## **A57 LINK ROADS**

**TR010034**

**RESPONSES TO DEADLINE 4 SUBMISSION**

**CPRE PDSY REBUTTAL OF NH'S RESPONSE TO OUR WRITTEN REPRESENTATION - REP2-069, REP2-070 AND REP2-071**

**6.4 Environmental Statement
Figure 7.8 - Visual Effects Drawings**

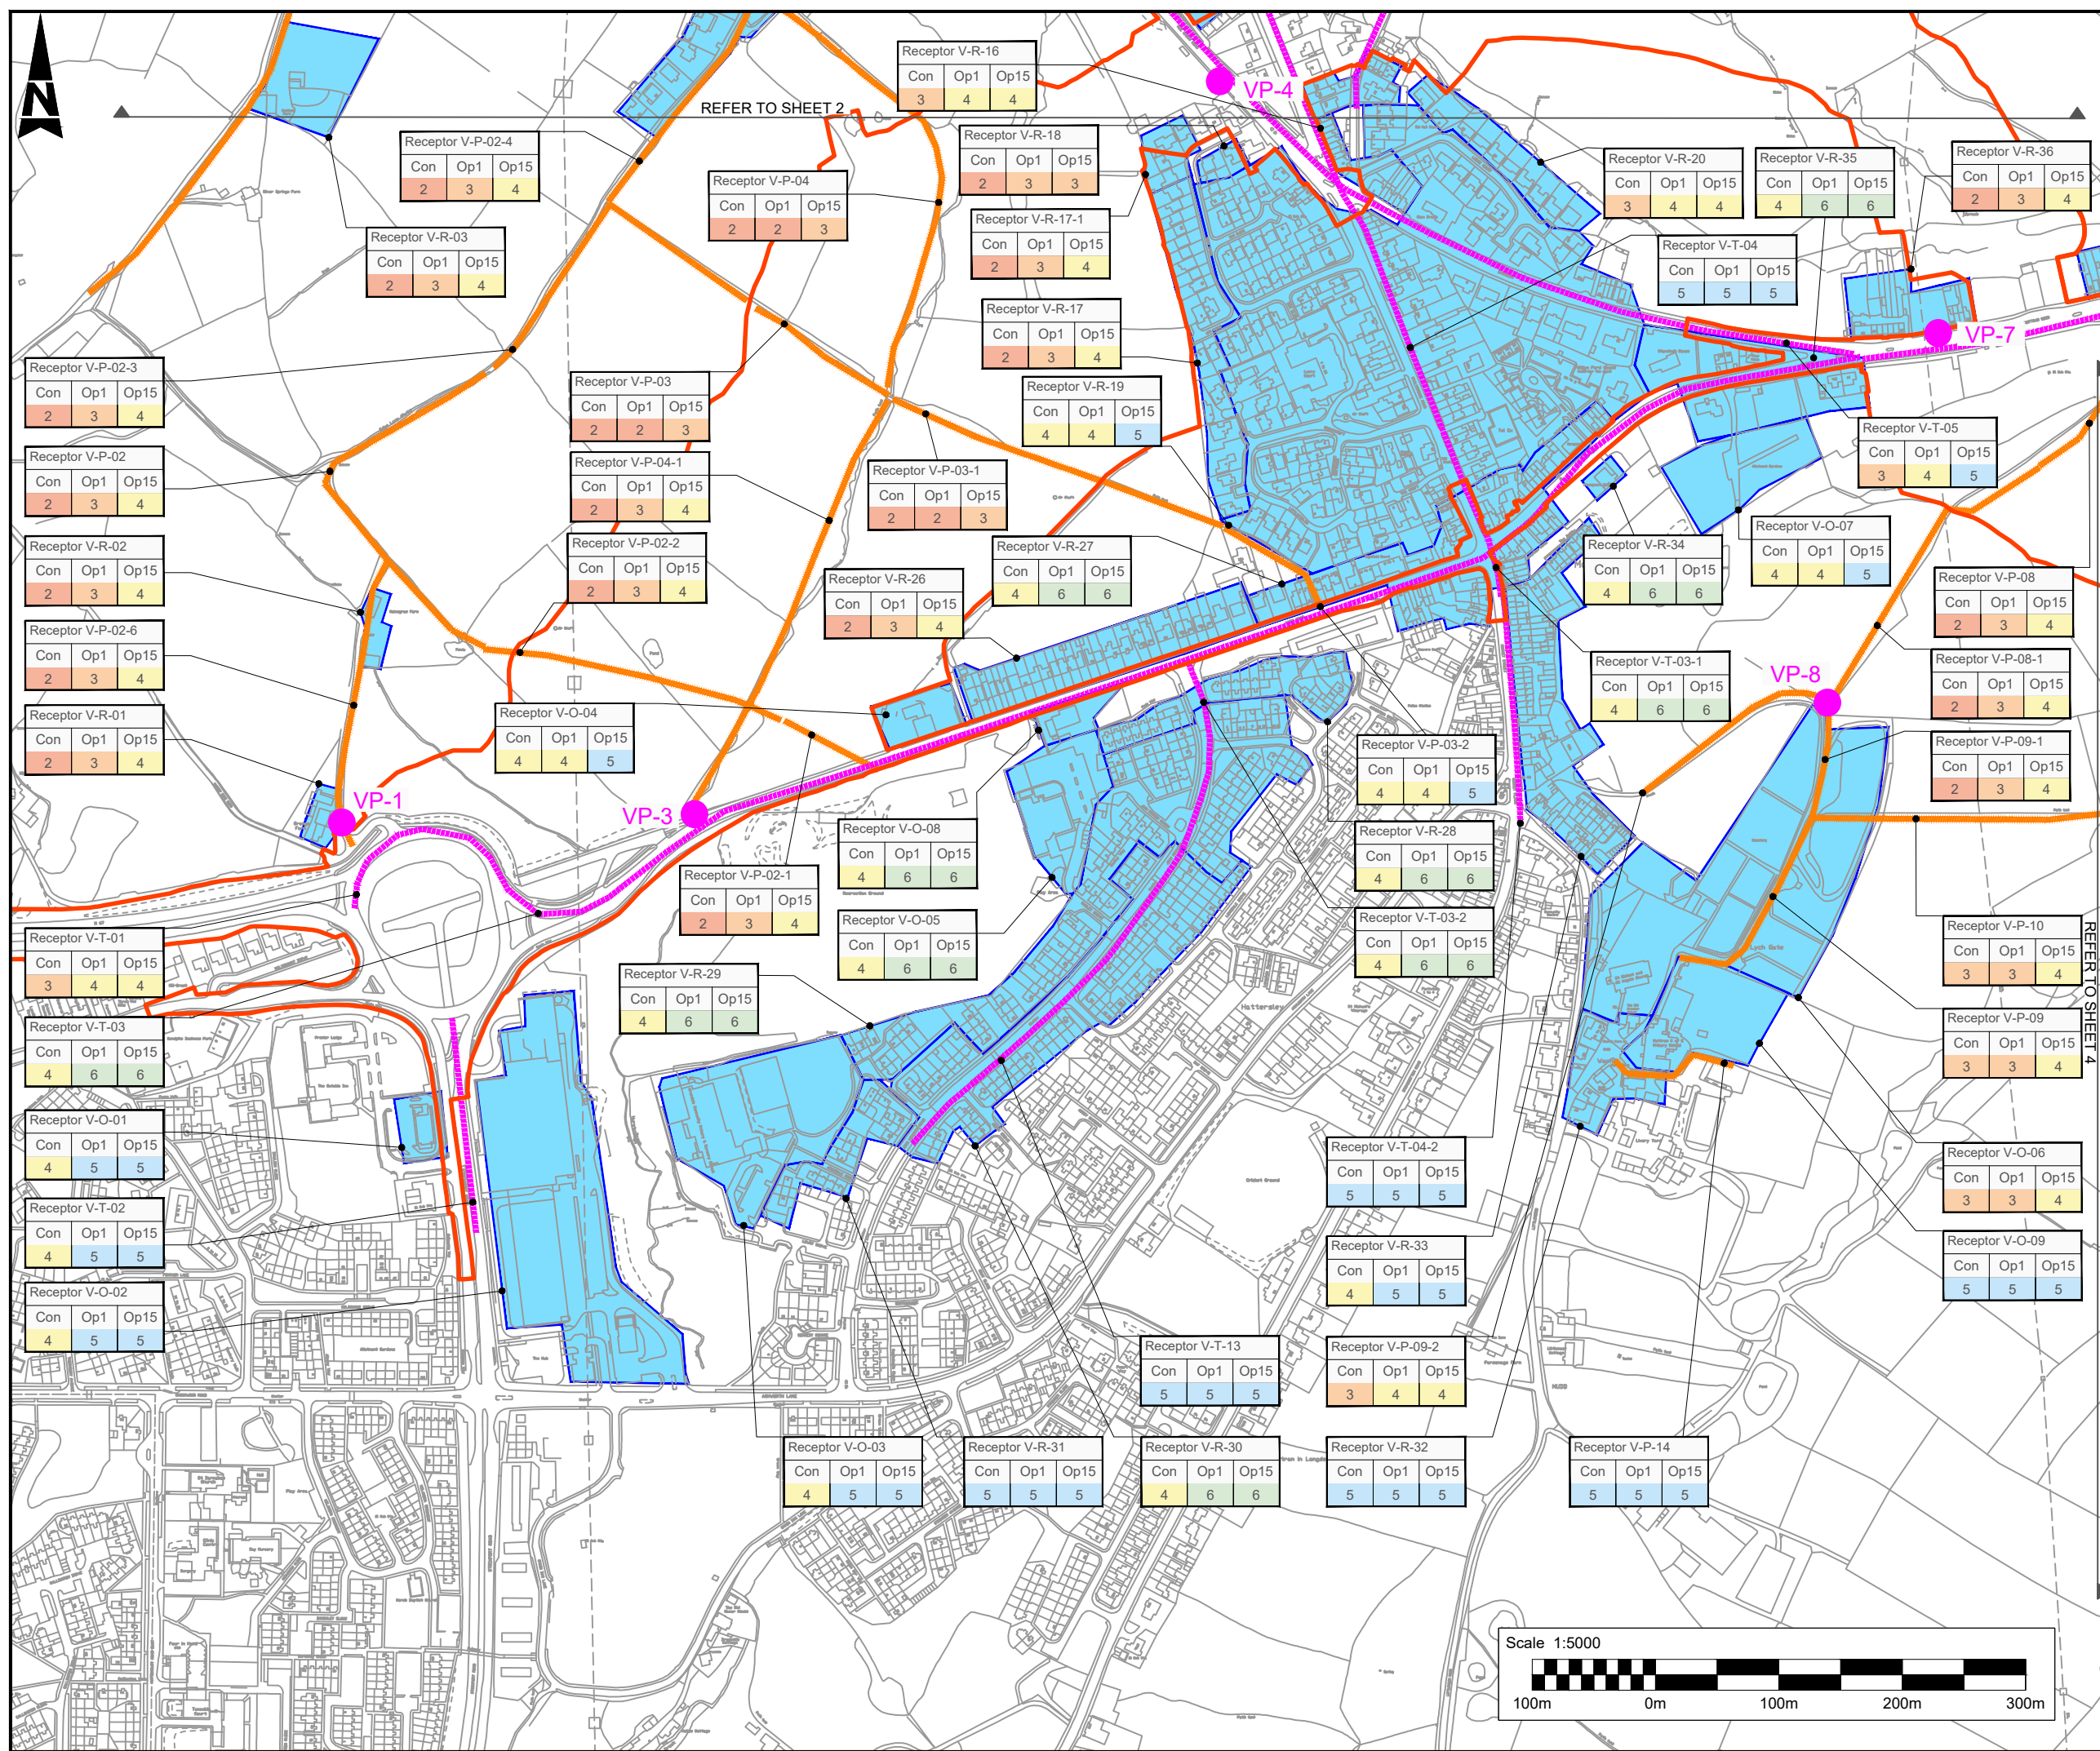
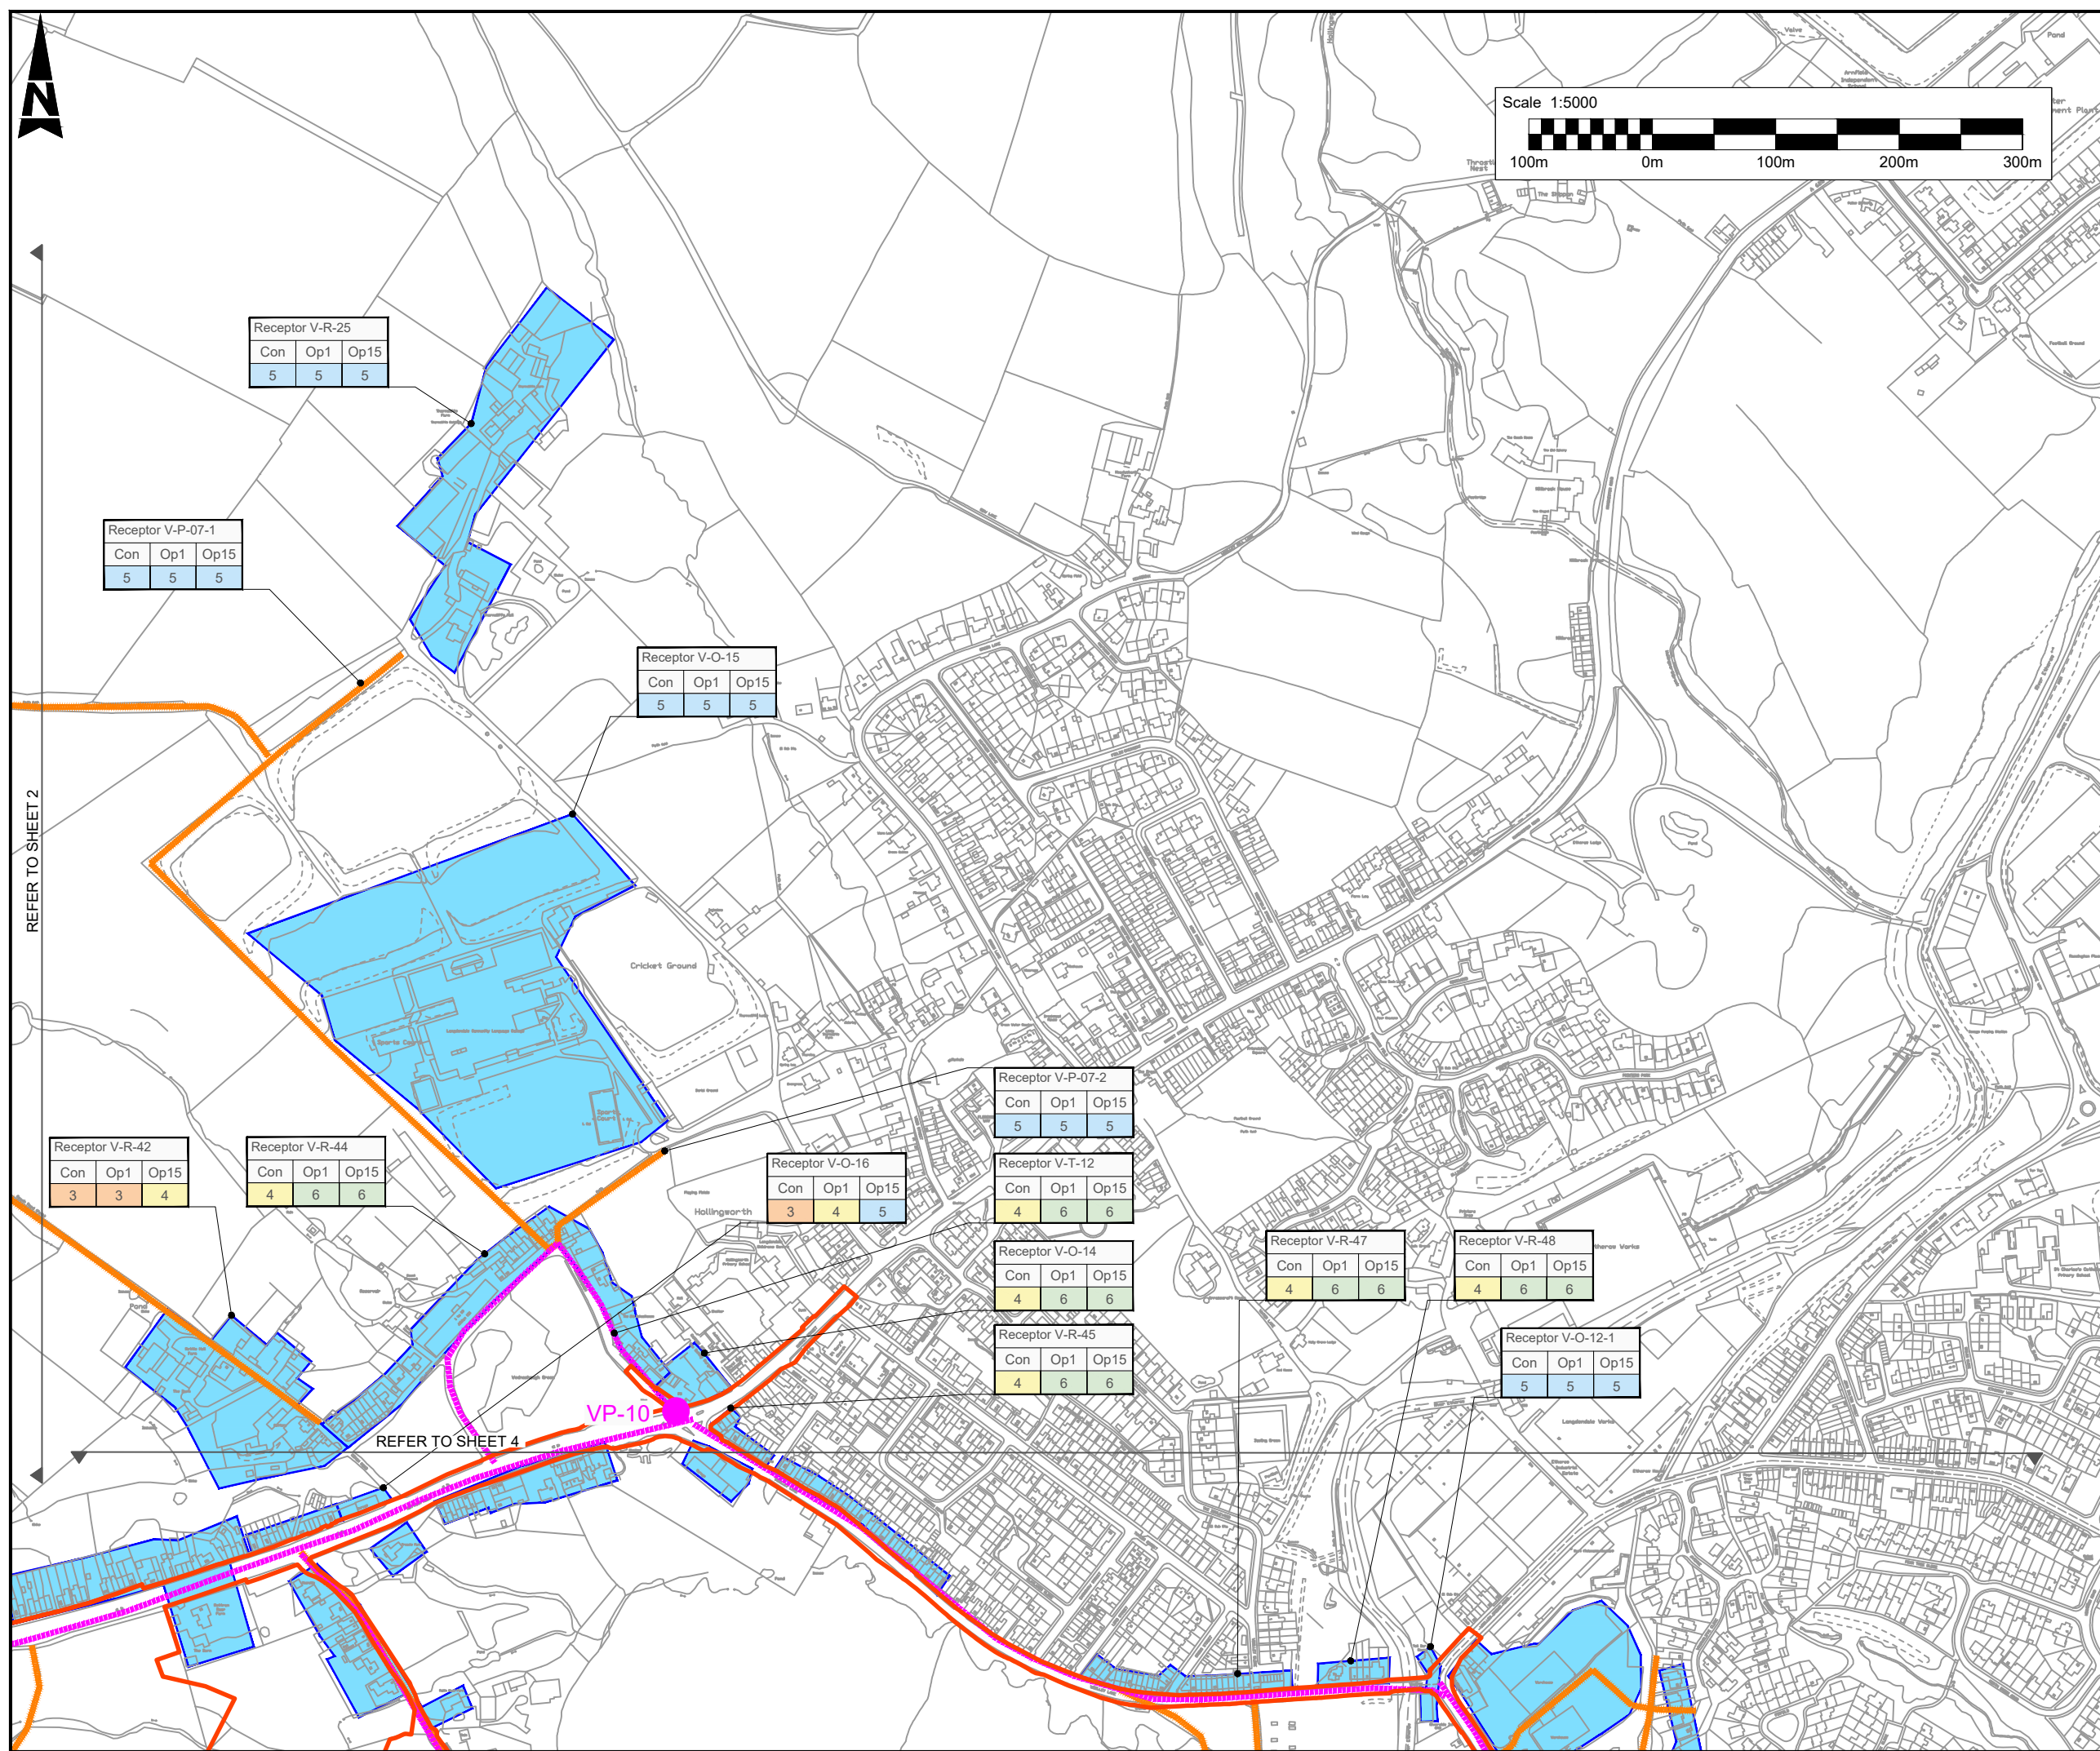
<p>Visual Effect</p> <p>6.2.17 The Applicant notes that a separate methodology is relied upon for the CPRE visual assessment, as per 4.7.48 through to 4.7.50 (REP2-</p>	<p>As above CPRE followed the guidance set out in GLVIA3. In our view NH's assessment did not fully capture or describe, and underplayed, the visual effects of the scheme.</p>

<p>069) (page 82), of the Written Representation and this is not clear (in terms of relevance and basis), and therefore cannot be commented on.</p> <p>6.2.18. As per ES Chapter 7: Landscape and Visual Effects paragraph 7.3.3 'A detailed landscape and visual assessment has been undertaken following the requirements of DMRB LA 107 standard. The assessment is also informed by guidance set out in GLVIA3 and GLVIA3 Statements of Clarification.'</p> <p>6.2.19. Additionally and as per ES Chapter 7: Landscape and Visual Effects Paragraph, Paragraph. 7.3.5: 'The assessment was undertaken by two chartered Landscape Architects (LA's) experienced in LVIA and their professional judgement was used in line with GLVIA3.'</p>	
<b>EFFECTS ON PEAK DISTRICT NATIONAL PARK</b>	
<b>National Highways Comments</b>	<b>CPRE PDSY Rebuttal</b>
<p>Increased Noise and reduced tranquillity</p> <p>4.8.19: Paragraphs 11.3.34 and 11.3.35 of the Noise chapter of the ES (REP1-017, REP3-007) provide details on how roads from the traffic model are selected for inclusion in the operation phase road traffic noise assessment. A map showing the locations of the roads within the study area of the Scheme is provided in Figure 11.5 (APP-134), which includes the A57 and A628. Traffic data from other roads located within the Peak District National Park were analysed for inclusion in the assessment, however, they did not meet the DMRB LA 111 requirements for inclusion in the study area as there were not predicted to change by 1 dB or more. Changes of less than 1dB are classified as negligible in the DMRB and would not be perceptible.</p> <p>7.2.2. 4.8.20: Paragraph 11.9.97 of the Noise chapter of the ES (REP1-017, REP3-007) states that minor increases were predicted on the A57 (Sheffield Road, Woodcock Road, Snake Pass and Snake Road) in the short-term and would be perceptible, and that negligible impacts would occur in the long-term. The impact magnitudes stated are based on the DMRB LA 111 assessment criteria reproduced in Table 11.9 of the ES.</p>	<p>We have responded to NH's approach towards tranquillity and dark skies in our submission for Deadline 4 REP4-016.</p>
